District: Cherwell

Application No: 19/00213/DISC-4

Proposal: Discharge of conditions 6 (new link road), 8 (surface water drainage), 9 (floor levels), 10 (play areas), 11 (arboricultural survey), 12 (ecology), 13 (secured by design), 14 (contamination), 18 (mitigation for badgers) and 35 (cycle lanes) of 15/01326/OUT

Transport Development Control

DRG. No:
 957-02-01 Rev A

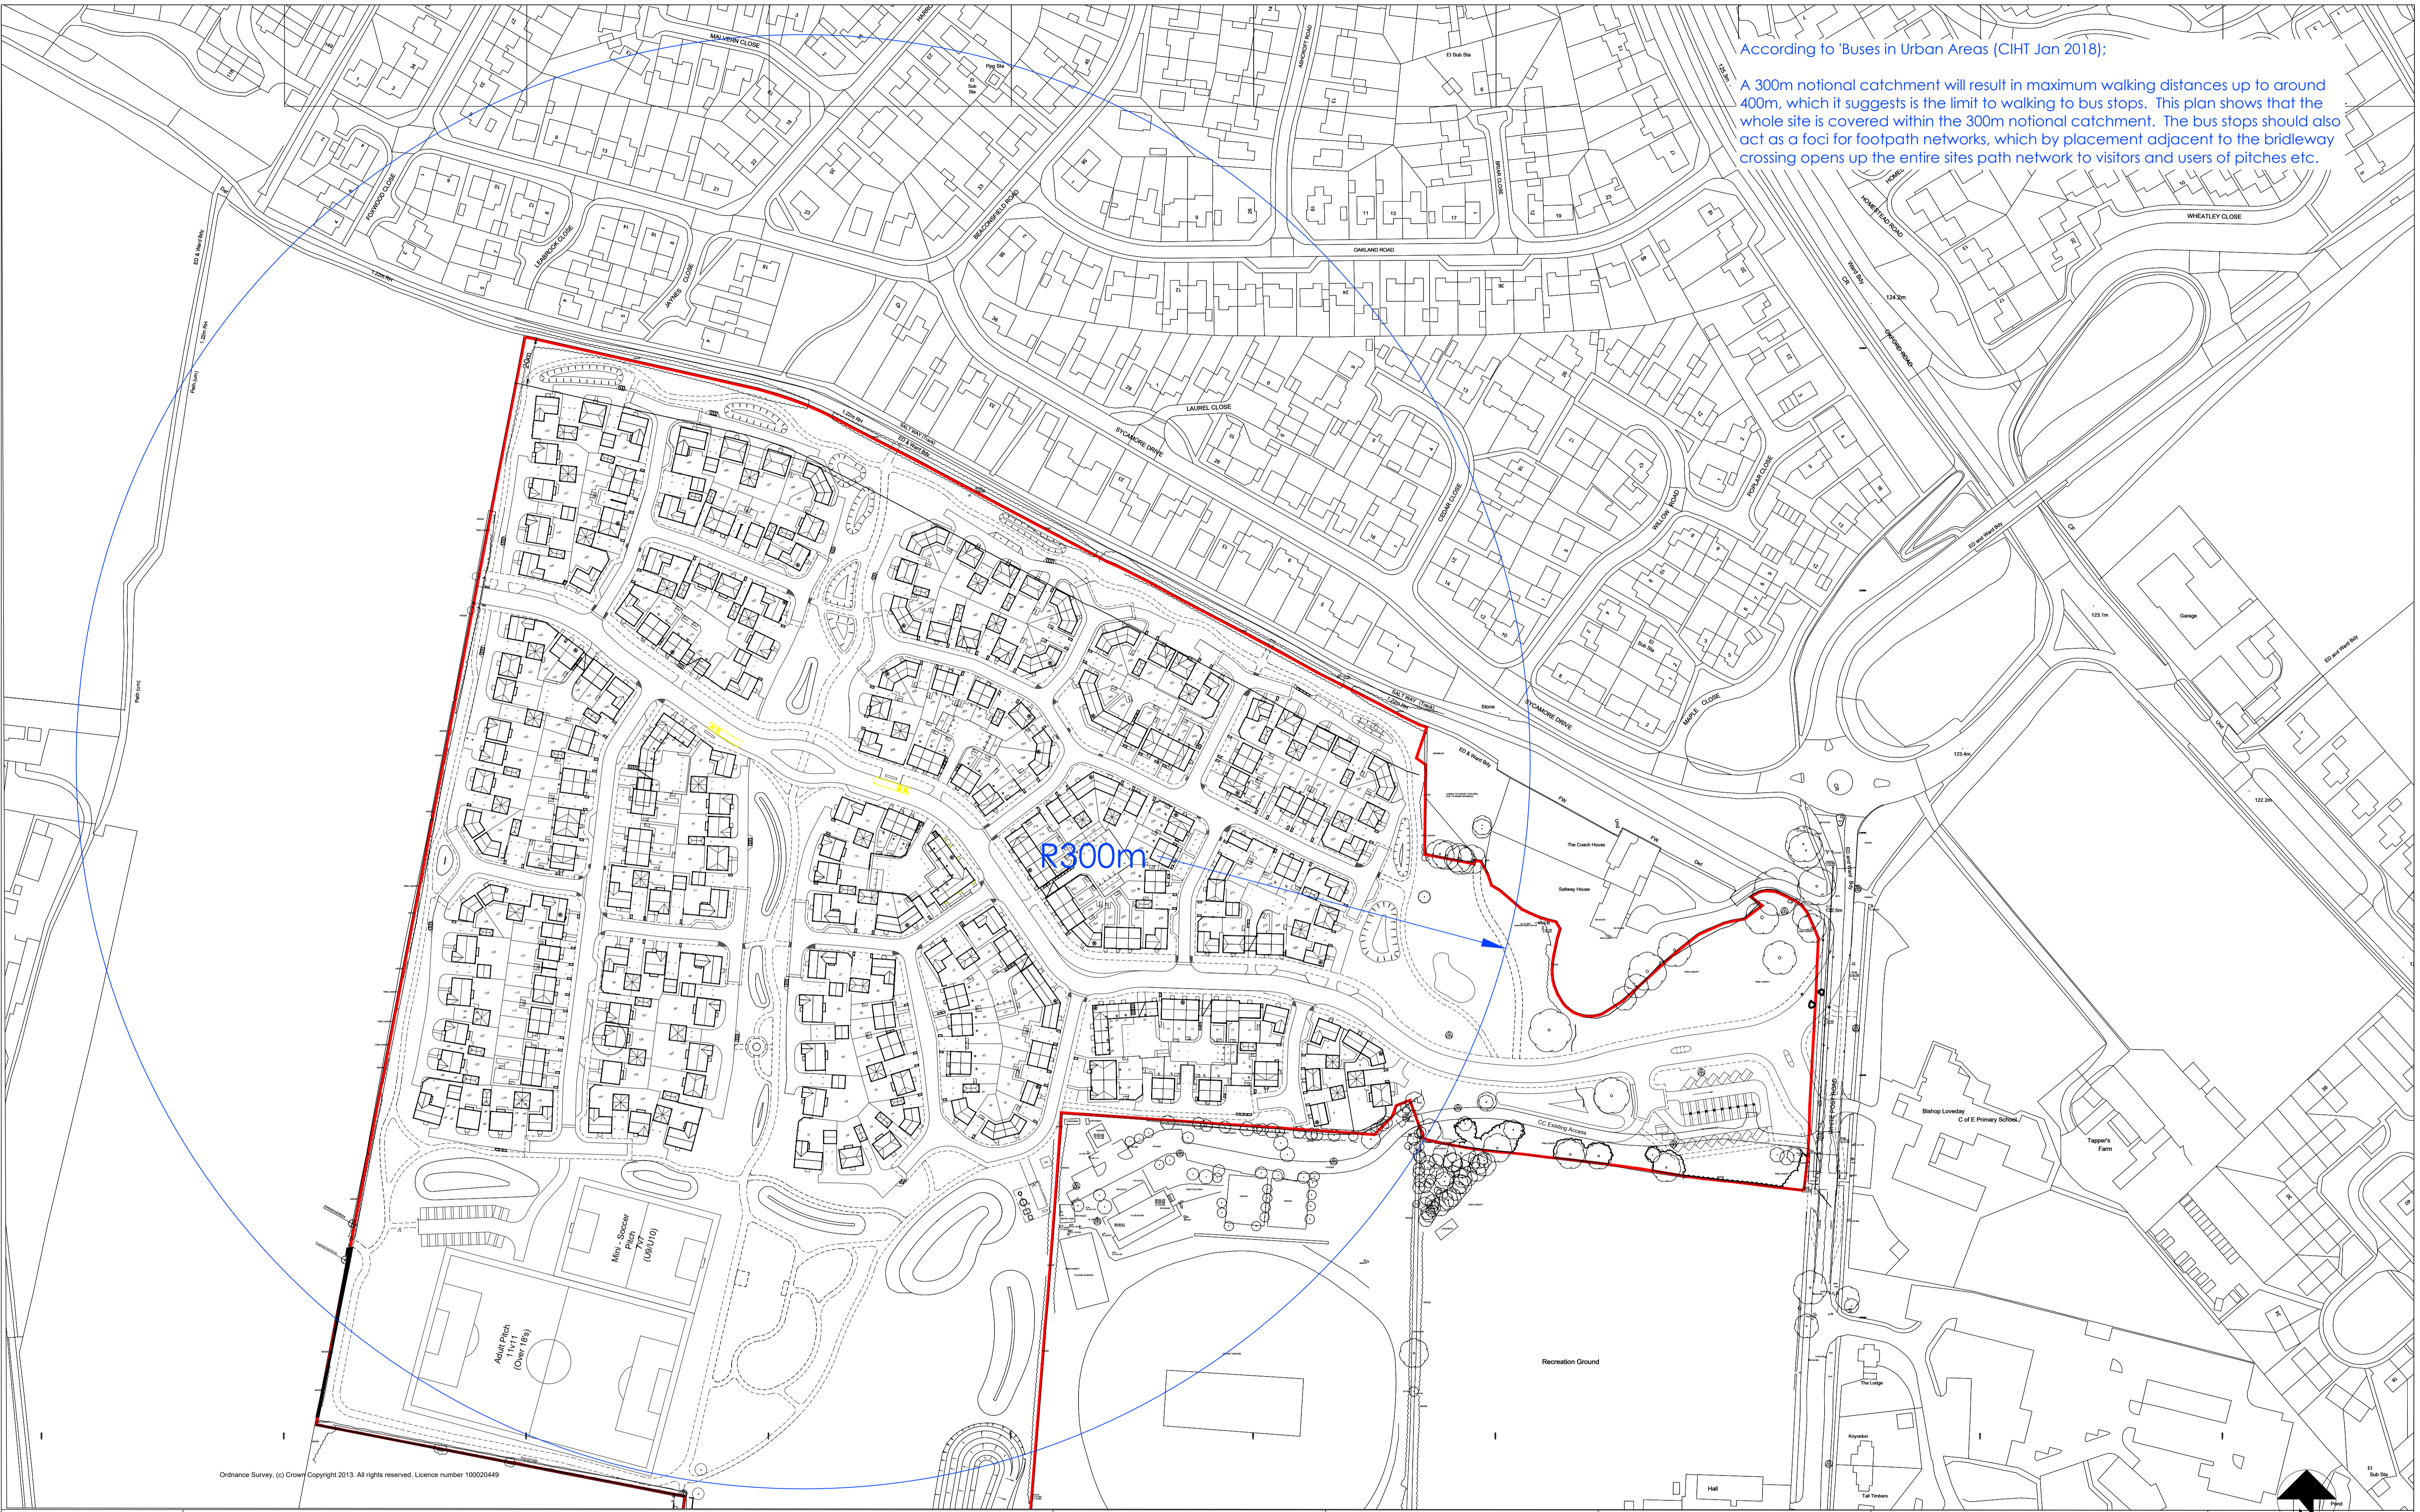
As a revision to the previous submissions, plans now show a 4m wide landscaped verge as a minimum on the northern frontage of the carriageway alongside a 3m wide shared footway/cycleway. This is in compliance with the layout approved at the reserved matters permission (Planning ref: 19/00895/REM).

Designated parking along the link road has been provided within laybys of two spaces each. The carriageway parking provision complies with the specification outlined in the UU and also to the layout of the approved reserved matters application.
